As requested, the following provides responses to ExA questions directed to IP's

LV.2.2 – Landscape and Visual. The plans which form Appendix LV.2 Trees to be Removed and Replaced at Coronation Avenue WQ LV.1.8 [REP1-044] are annotated 'Draft'. The Applicant is asked to explain how this relates to the requirement in R5(3) of the dDCO for the landscaping scheme to include a strategy for the replacement of trees which are to be removed at Coronation Avenue? IPs are asked to comment on the proposals for Coronation Avenue.

© WSP UK Ltd

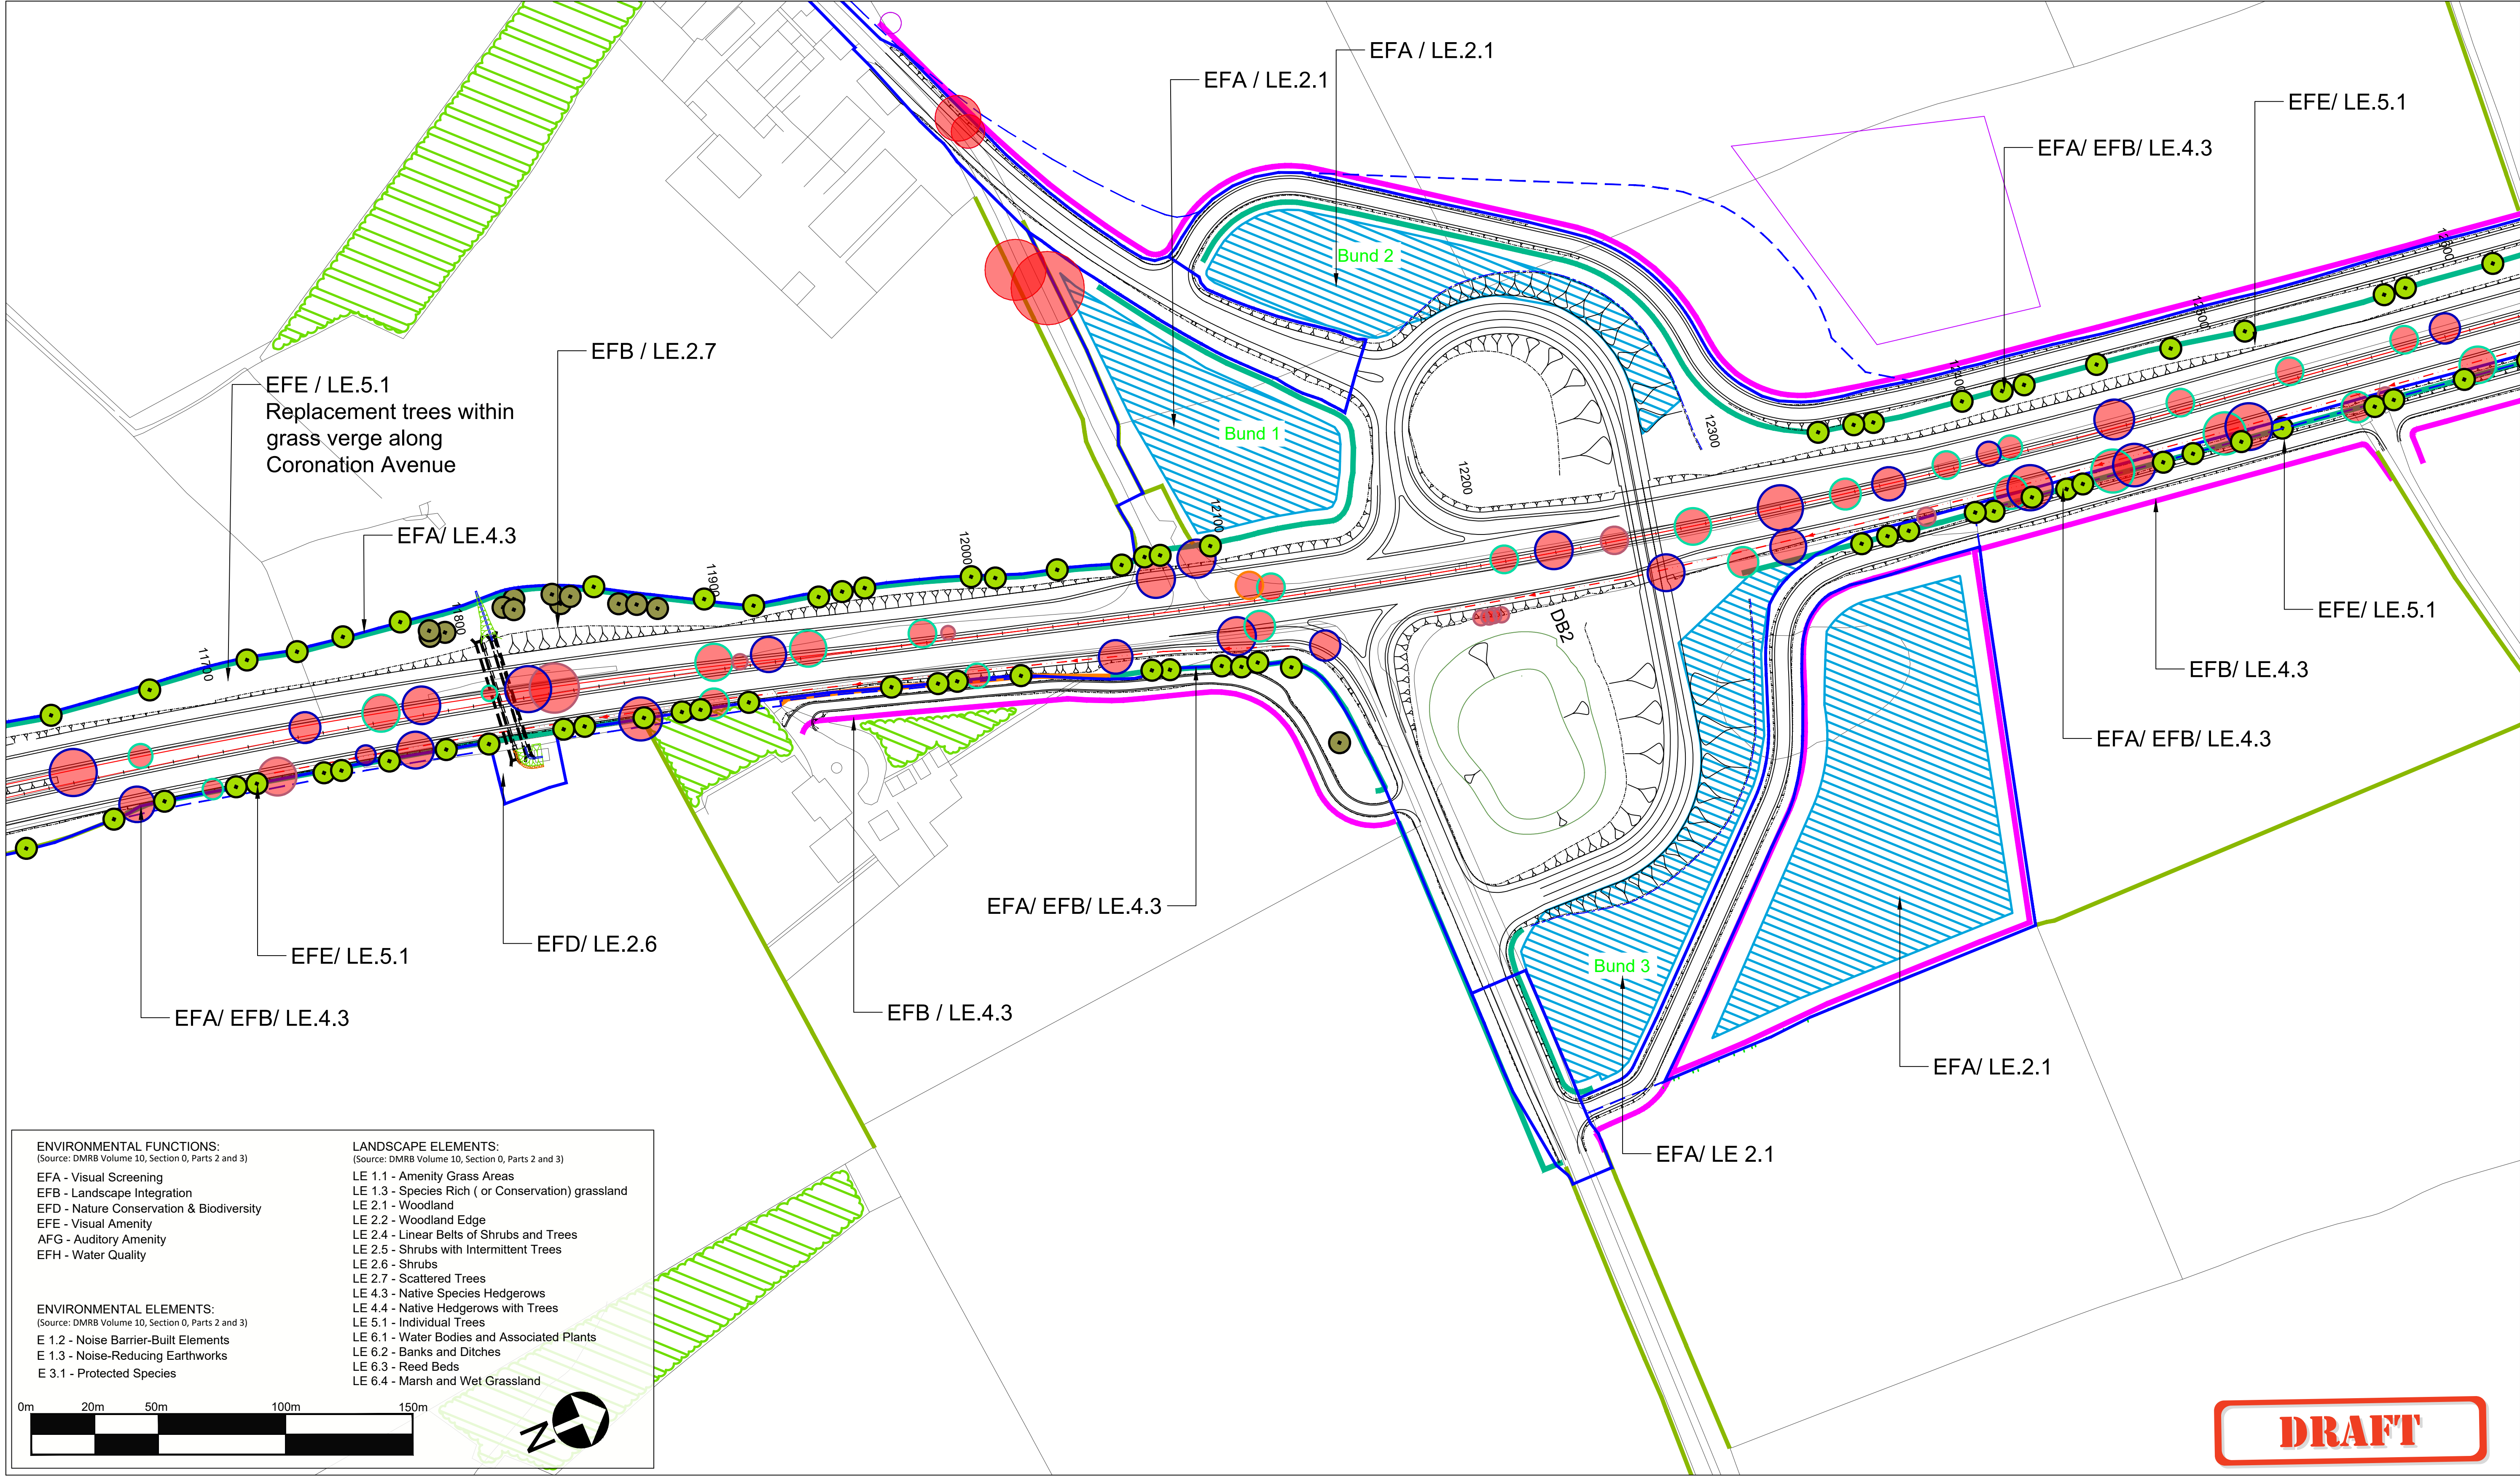
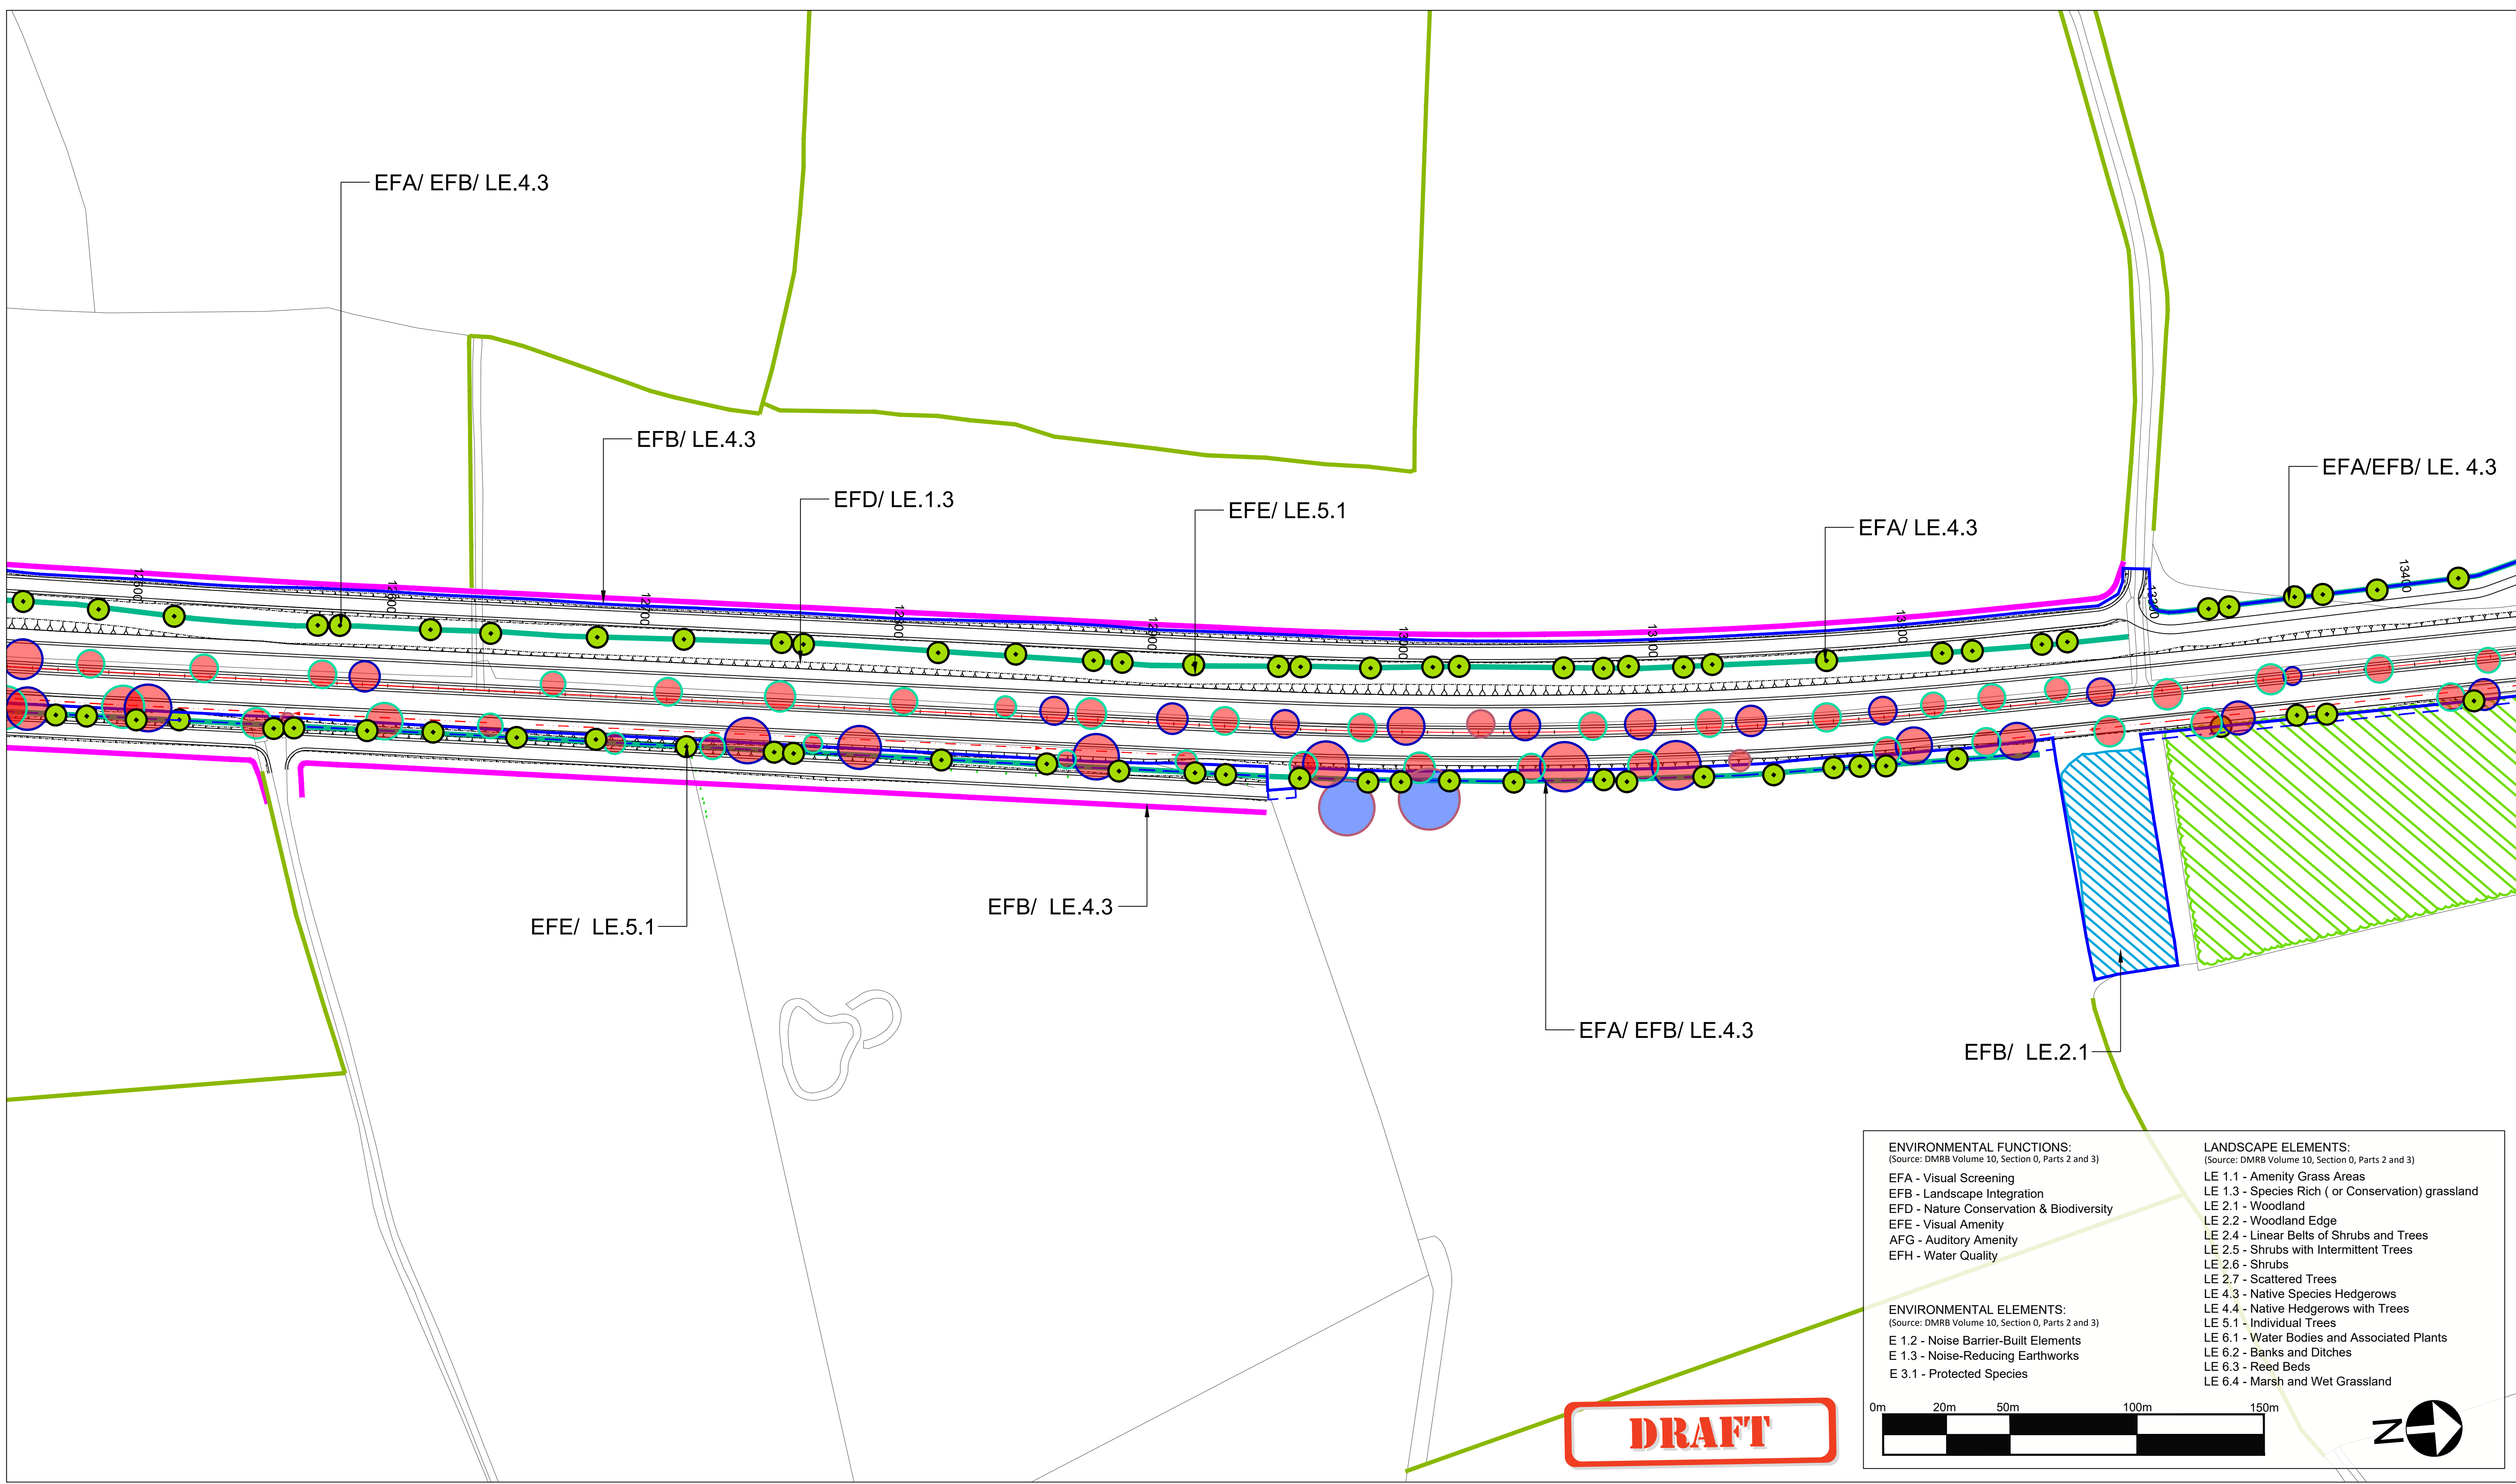
1. In reviewing this documentation again, I remain disappointed by the scale of tree loss inflicted by the scheme. Undoubtedly the biggest impact is on the distinguished Coronation Avenue of trees which line both sides of the single carriageway. I am not aware of any other A classed road in the country which can boast such an extensive configuration of mature trees, which are now approaching 70 years age. The main source of frustration stems from an underlying belief that more could have been done to protect the trees and improve the levels of mitigation. For example, most of the work carried out on the existing road is asymmetric which means that the eastern edge of the road has been spared some of the major works. Unfortunately, this does not appear to have provided any extra protection to the trees on the eastern edge.

2. In total it appears that circa 200 coronation trees are to be felled and replaced with young trees which I understand will take a minimum of 15 years to mature. Even then the visual impact and environmental contribution will remain well short of what we enjoy today.

3. In looking at the plans for the new arrangement of replacement trees the Avenue effect would appear to have been lost. The configuration of the trees is no longer linear and there are too many gaps in the flow to emulate the Avenue effect. Furthermore, the distances between the trees flanking each side of the road are over 50 metres in some cases.
